SUTHERLAND ENTERTAINMENT CENTRE MAJOR REFURBISHMENT

Design Integrity Panel Report for DA

# *Foyer Design*

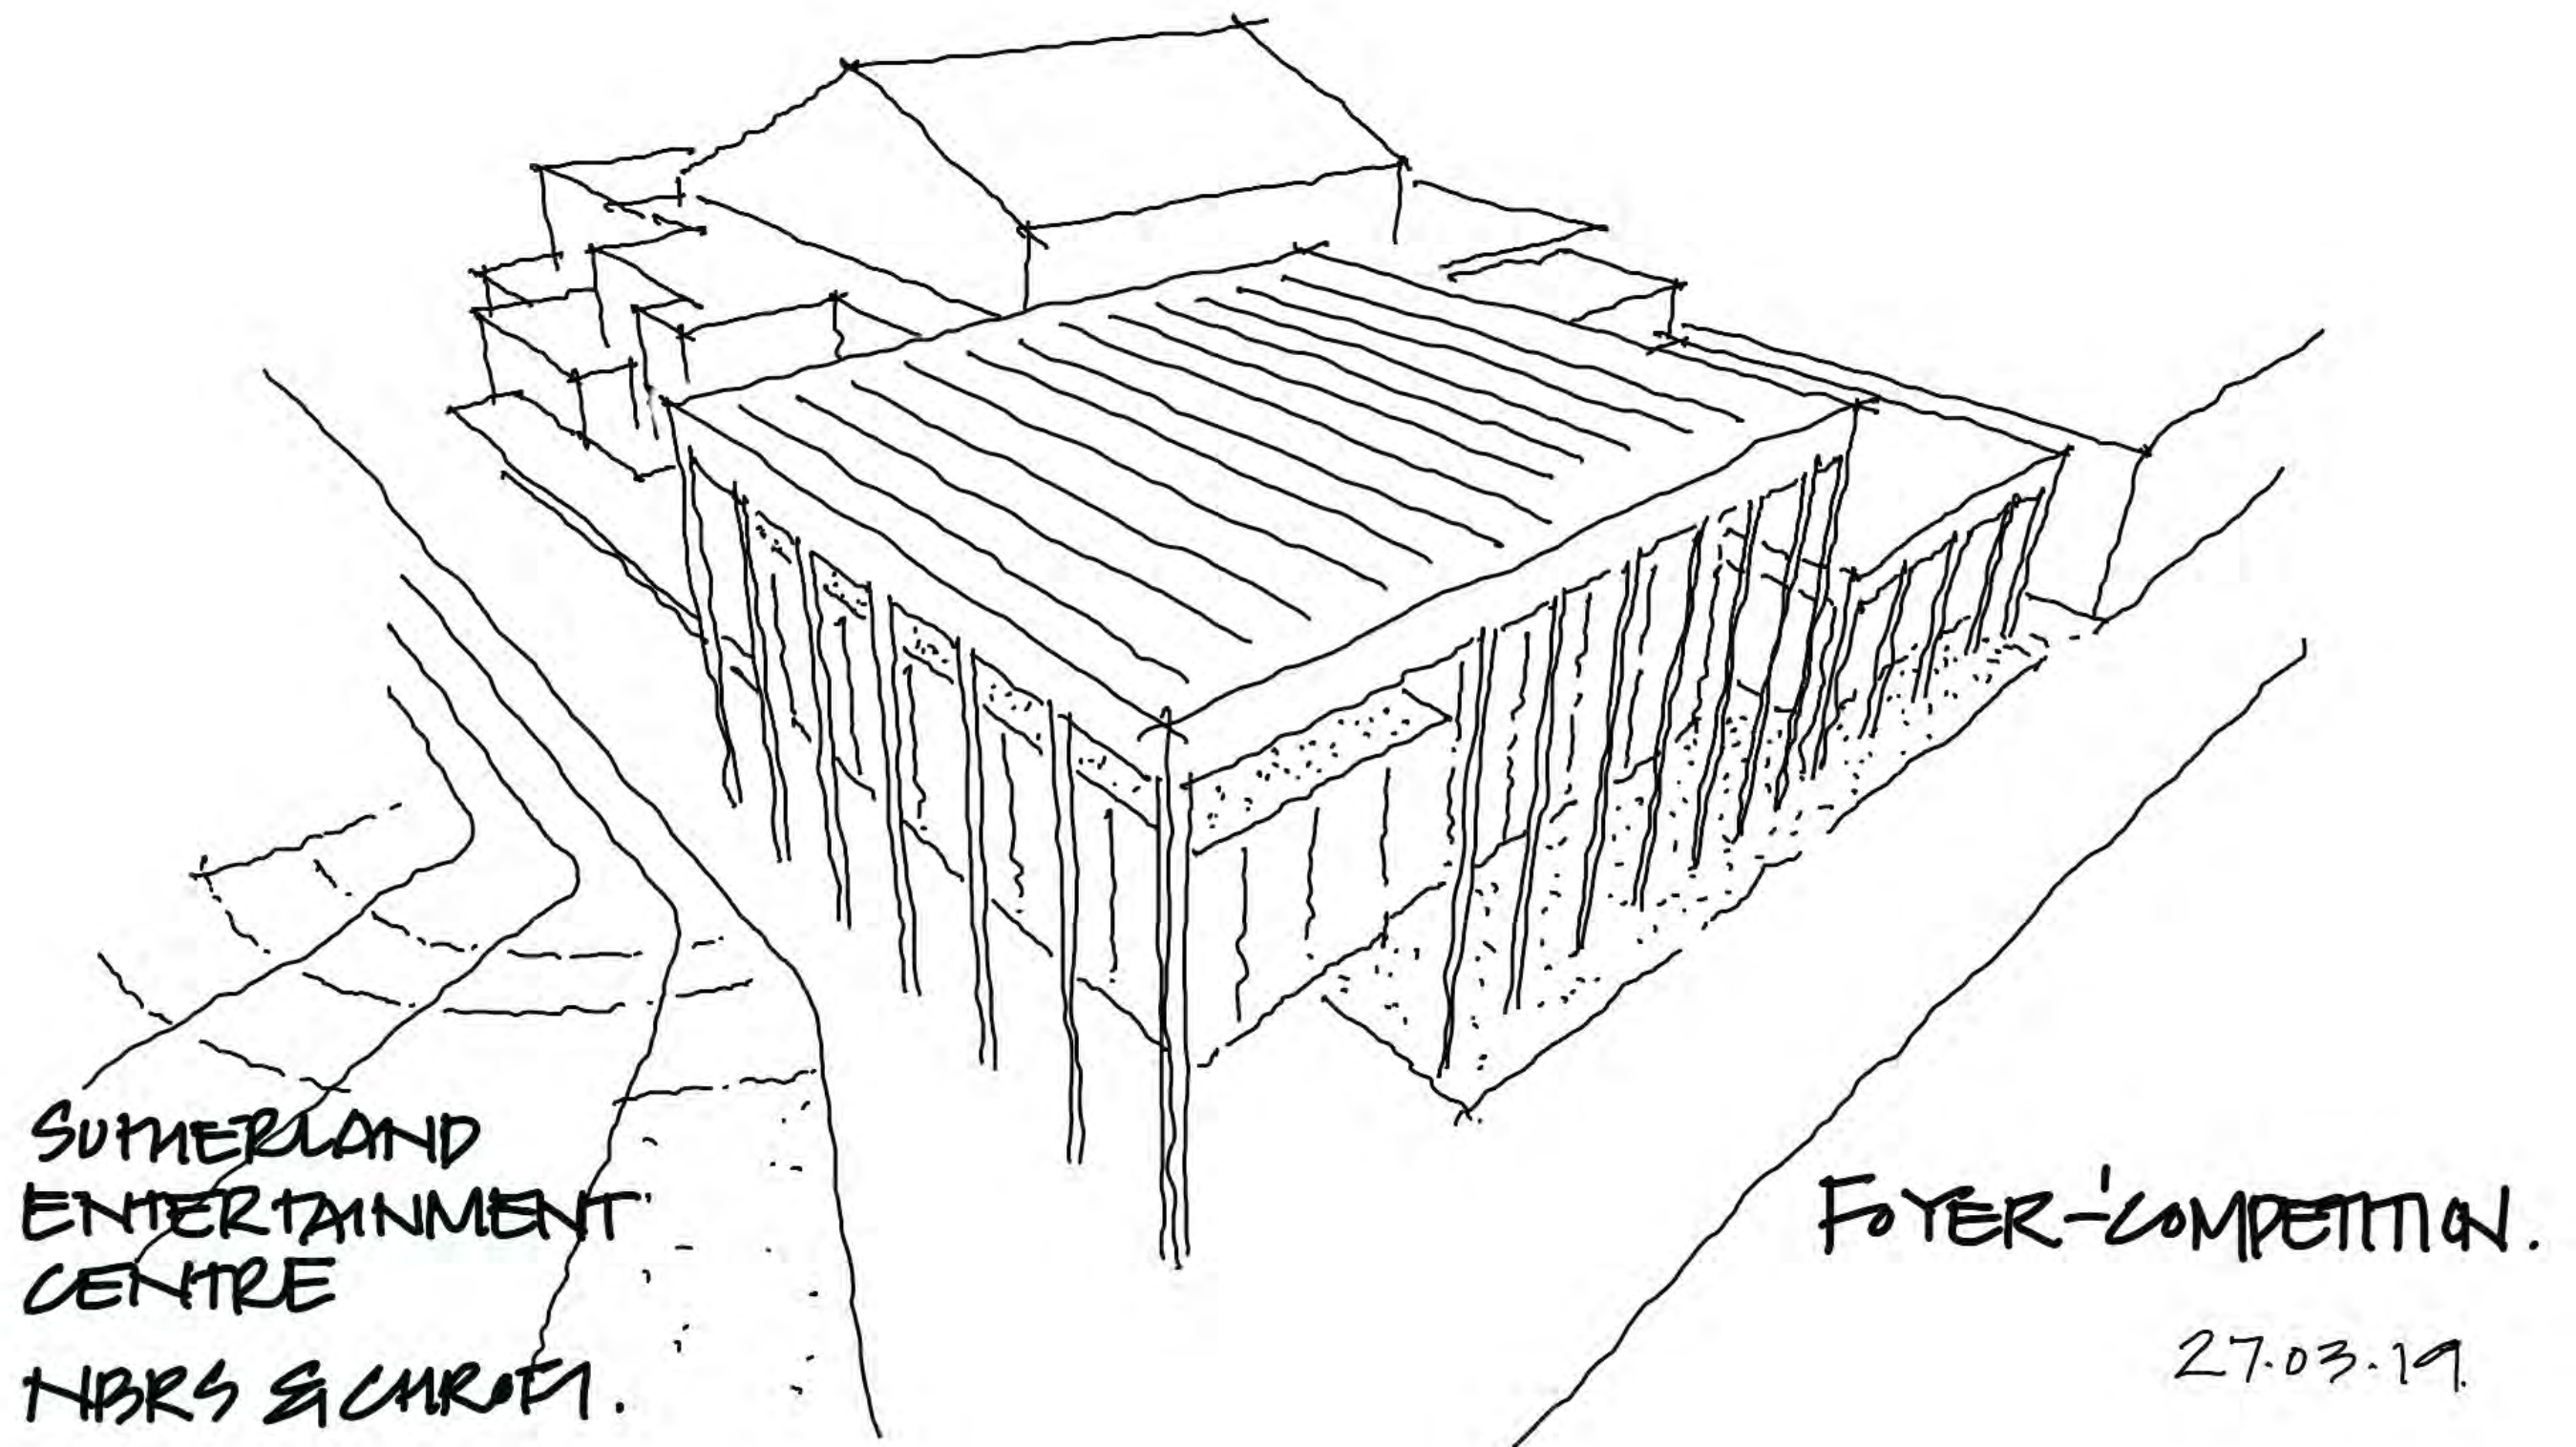
1. The Panel observed from the images presented, as well as the project model, that the slenderness of the foyer columns appeared disproportionate to the foyer height. The number, spacing and size of columns seemed to be a departure from the tender design.

1. The Panel supports the removal of one column from the western façade shown as Option 1 in the 10th December Presentation documentation addressing concerns around the proportions of the foyer structure.
